EARLY GRADING AND EROSION CONTROL PLANS

SPRINGS AT WATERVIEW

EL PASO COUNTY, STATE OF COLORADO

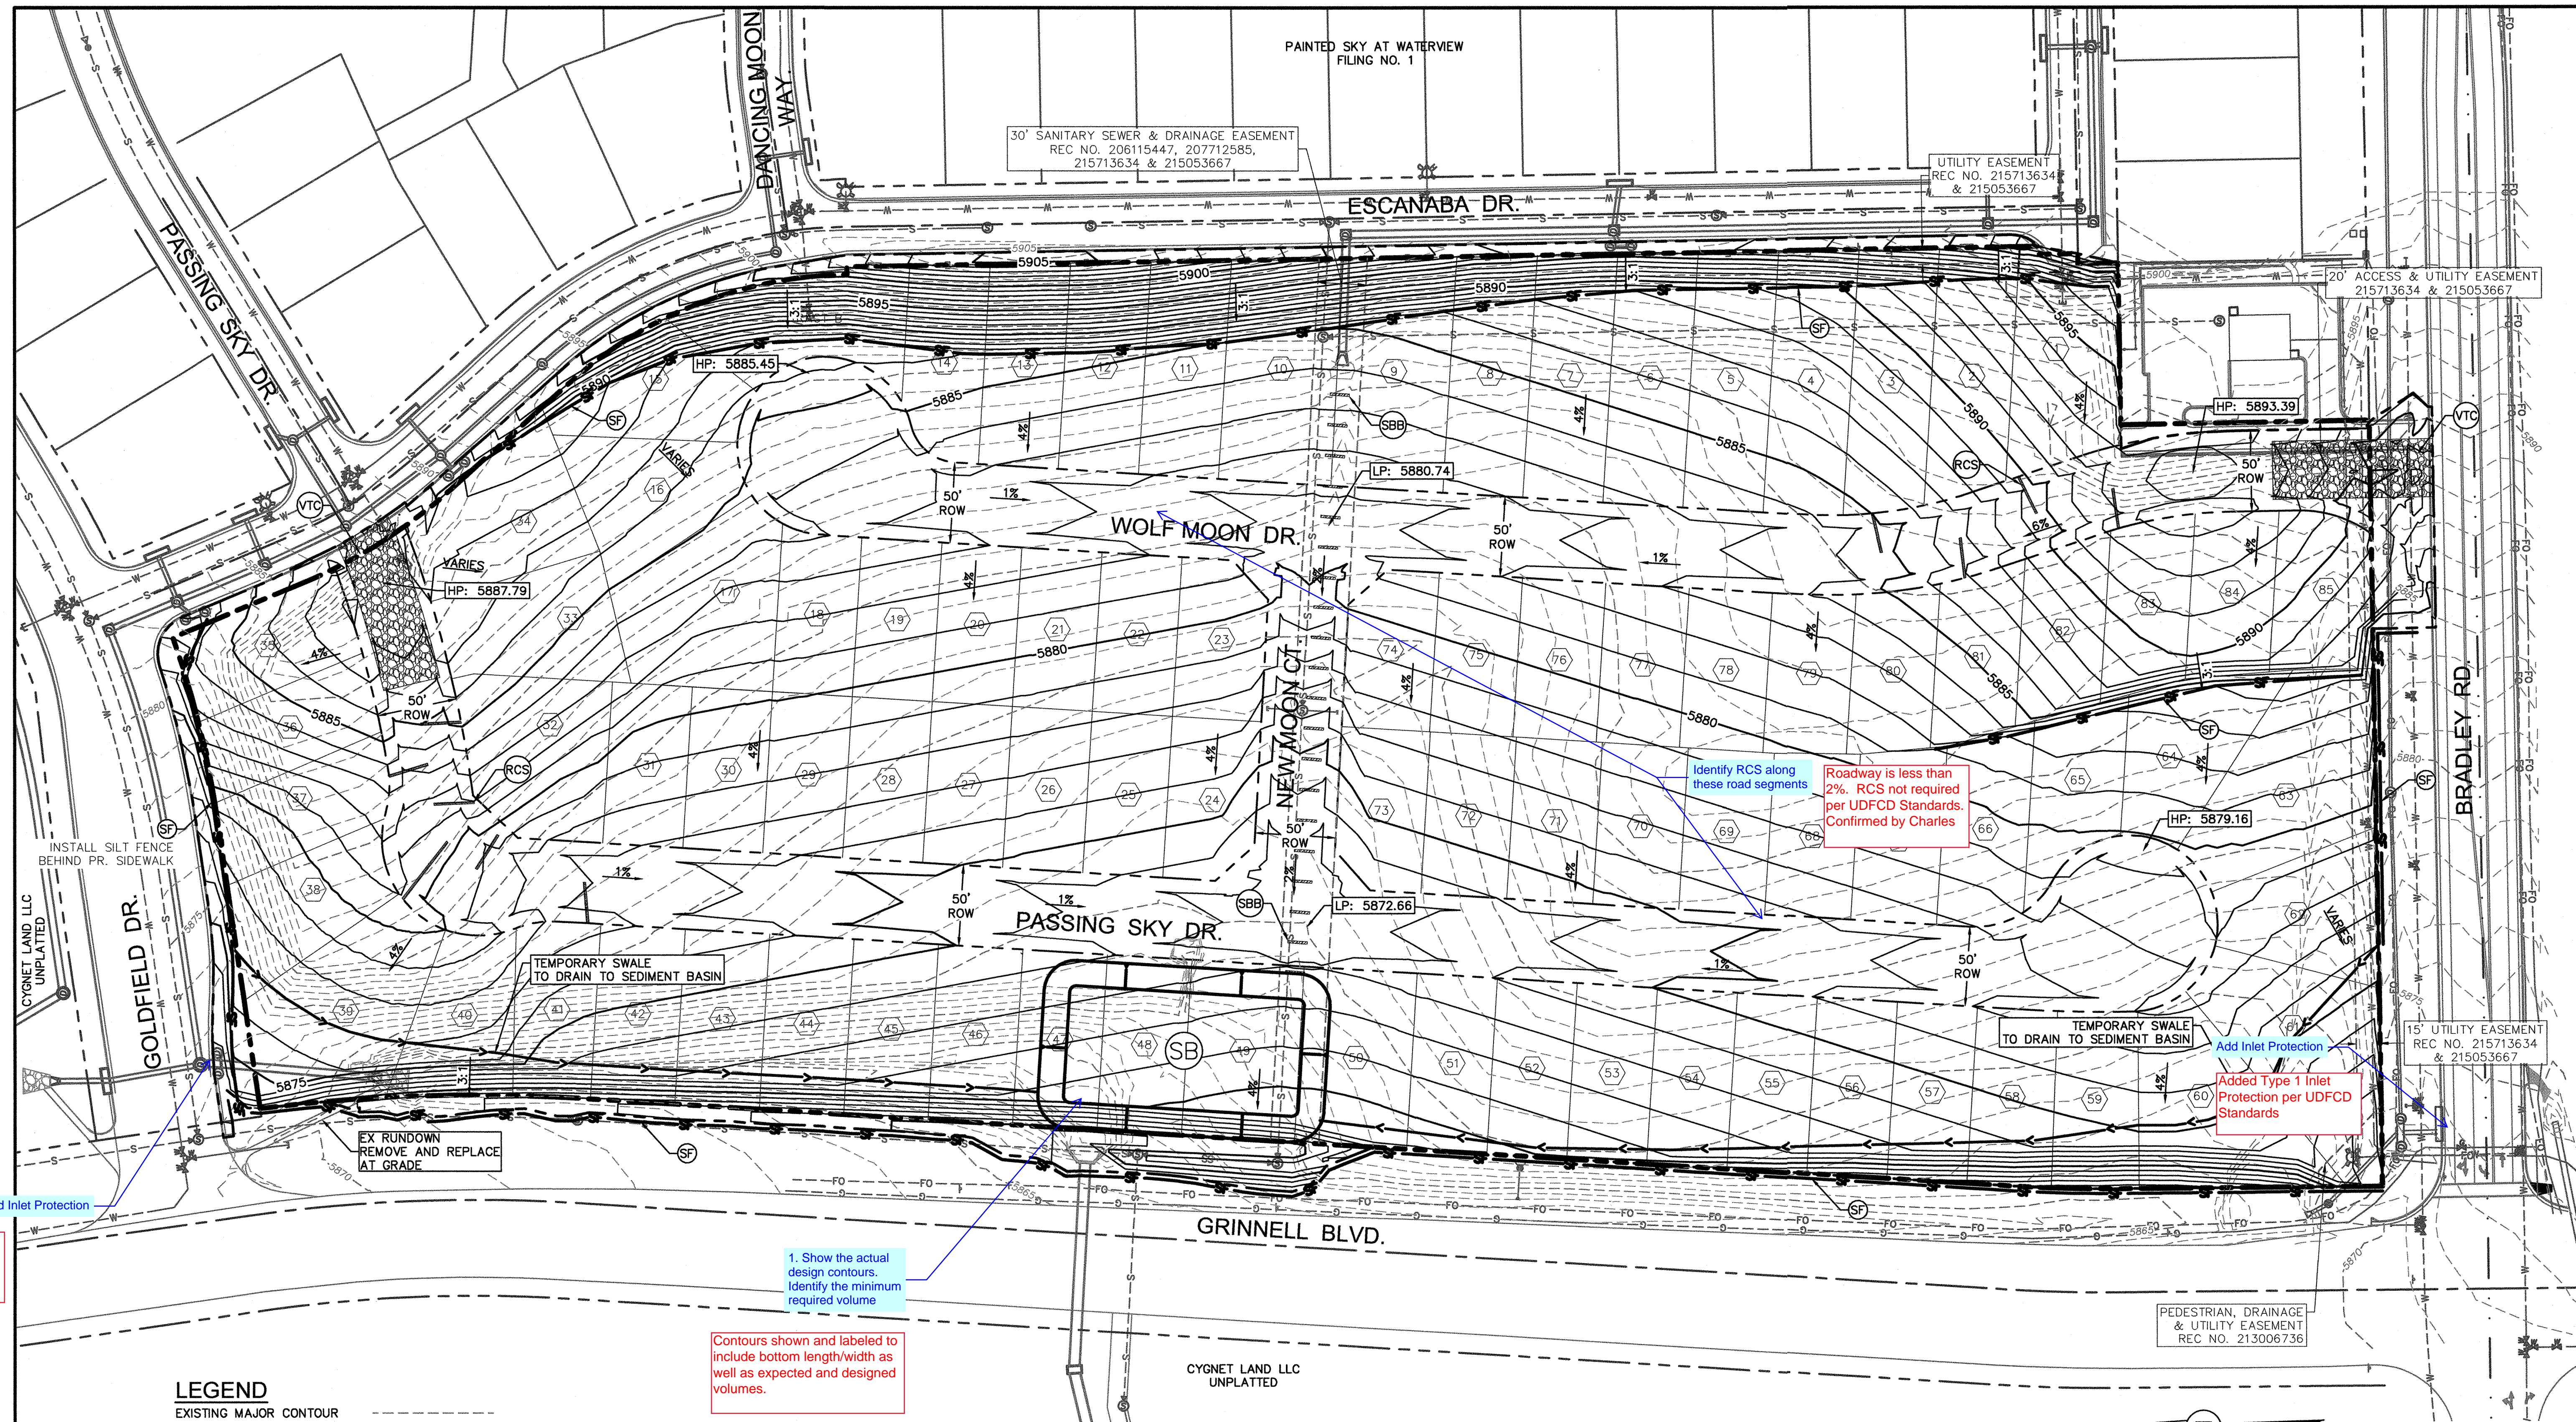
Unresolved. Identify on the plan view or the detail the required orifice hole diameter for the riser pipe. Additionally, show the riser pipe and outfall layout on the plan view
